2 May 2022

Re: Sydney Metro West SSI-22765520 – GPT Submission

We write in relation to the exhibition of the Sydney Metro West (SSI-22765520) project, involving the major civil construction (consisting of tunnel fit-out, station building and fit-out) and operation of the “game changing” metro line between Westmead and Sydney CBD. This submission follows on from the GPT Group’s (GPT) earlier submission made in relation to Stage 1 of the Metro West project (SSI-10038).

Figure 3 Sydney Olympic Park metro station construction footprint

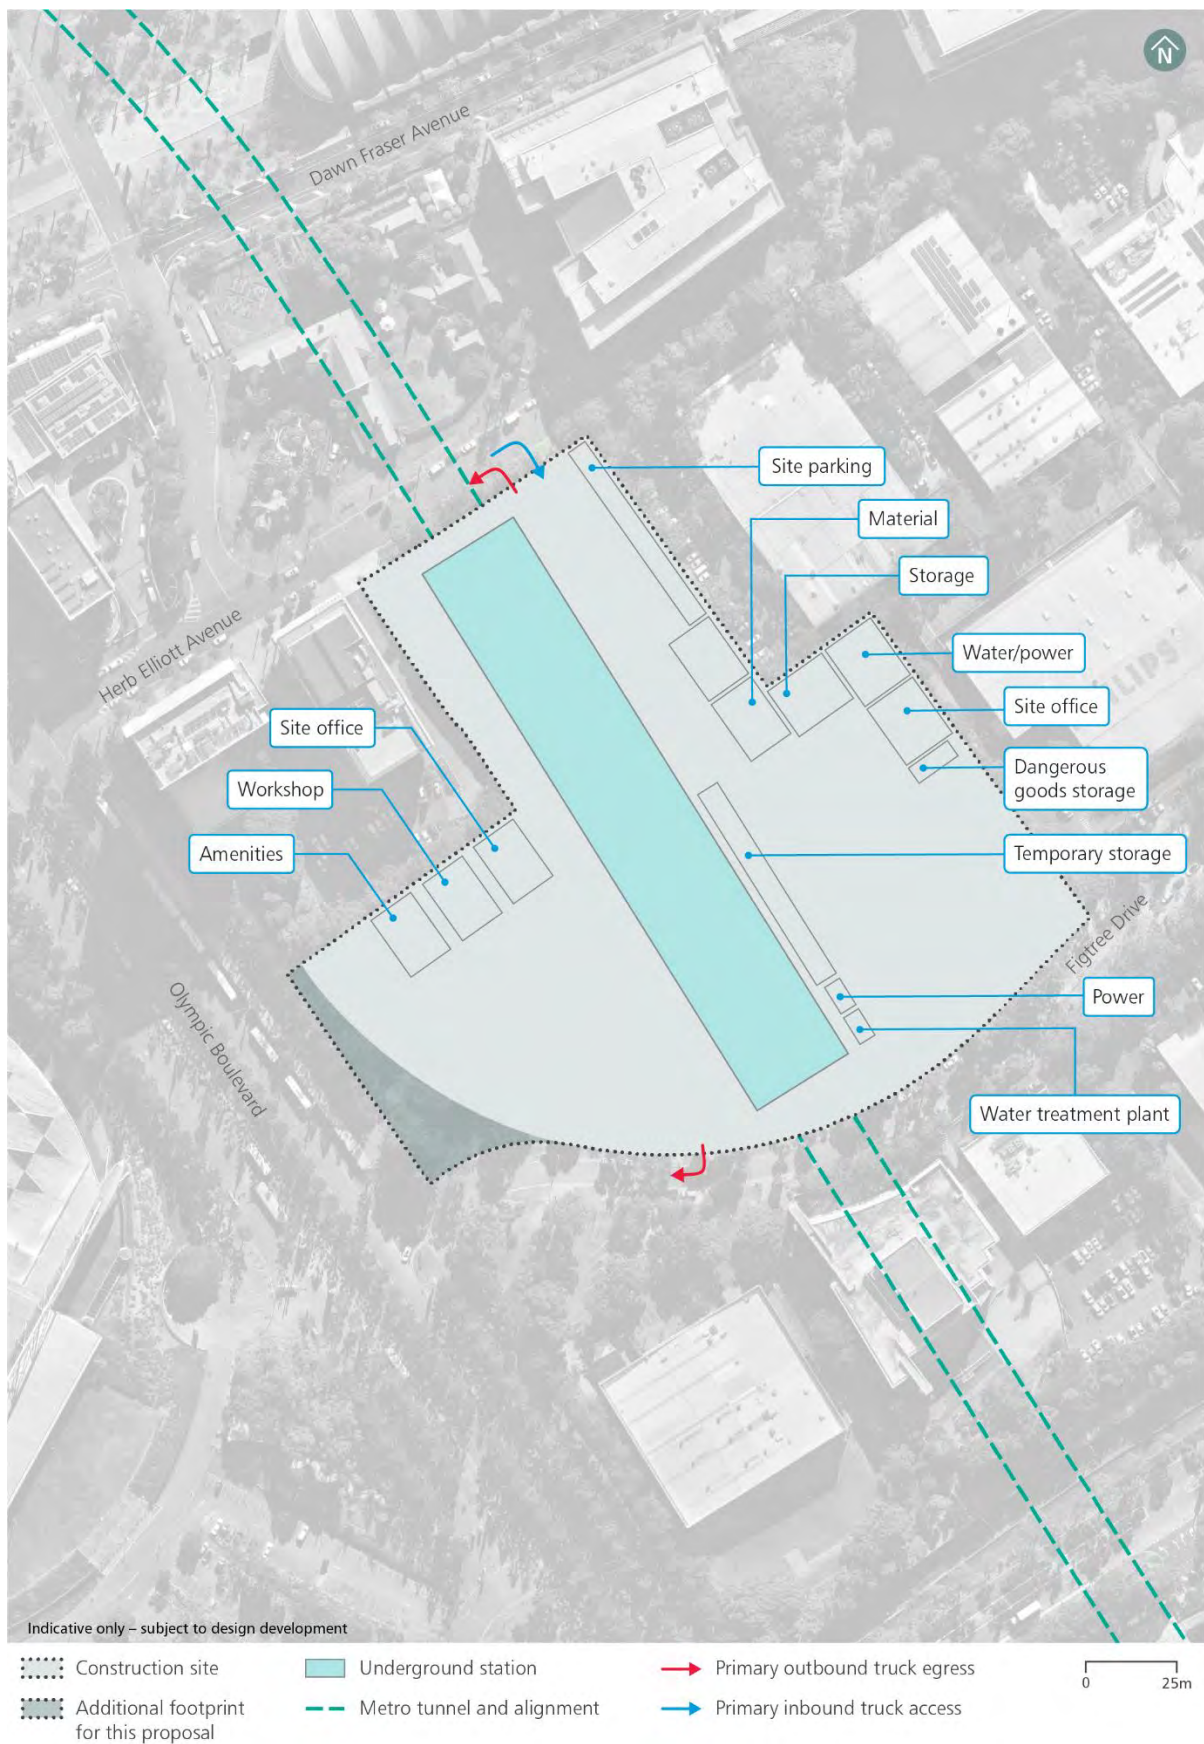
Whilst the Design Guidelines articulate “Active uses at ground level (fine grain)”, Chapter 9 does not articulate the nature of these uses. There is also no detail around the expected use and function of the “space for non-station use” above ground level and within the station box proper. Given GPT’s interests neighbouring the precinct, we would appreciate briefing on these proposed uses and relationship to our future plans and the Central Precinct as a whole.

GPT generally supports the proposed approach to the station entry locations, along with the varied use from “Day to Day” to occasional “Event Mode”. However, we believe that positioning and focussing the “Day to Day” entries and associated pedestrian movements to the northern and southern ends is a missed opportunity and will potentially undermine the collective objective of creating an activated and vibrant Town Centre. Sydney Metro should give consideration as to how the Metro Station entries can be utilised to support a successful Town Centre.
